Subject: FW: AW/237/19/PL The Former Ship Inn, Aldwick

I now have our Highways comments. Just one thing, can you comment on the point she raises in her email below about the bollards.

Tracking Plan : Option 3
scale 1:500 @ A1

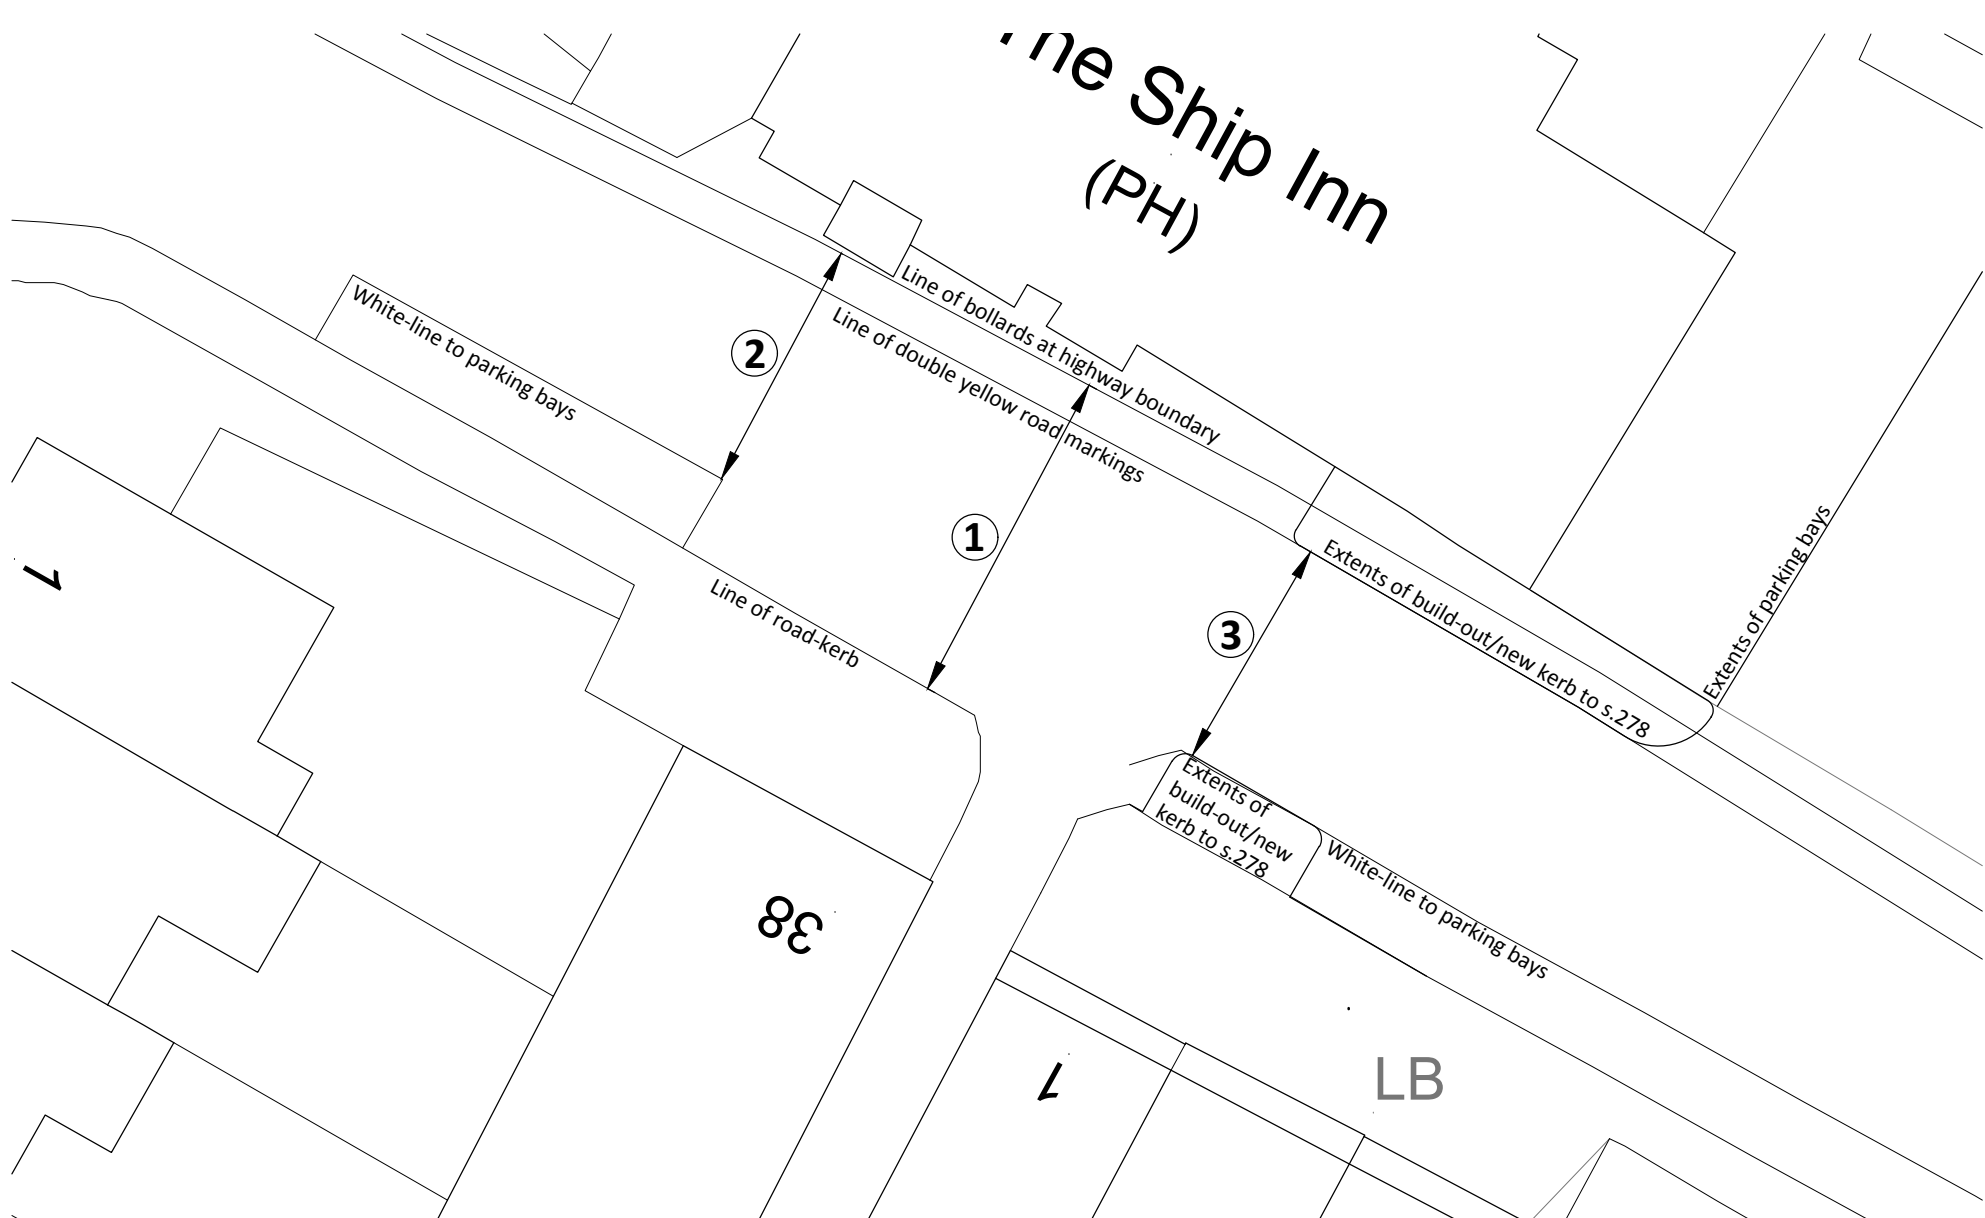
Many thanks for the documents which I have been able to review and provide some comments for you, attached. Whilst the RSA does not propose anything new to what has already been approved under the original planning approval, the updated tracking does show that an articulated lorry would not be able to use the car park for loading and unloading without over running the northern buildout. We have also noticed that any articulated movements should preferably travel to the site from the west and leave from the east to avoid over running the northern build out. This should be reflected in the delivery management schedule. Clarification should be sought over whether the existing bollards in the highway will remain, as it is not clear where these are in relation to the tracked vehicle.

The part about delivery vehicle movements can be covered by the delivery management schedule condition on the original permission so no need to update the schedule.
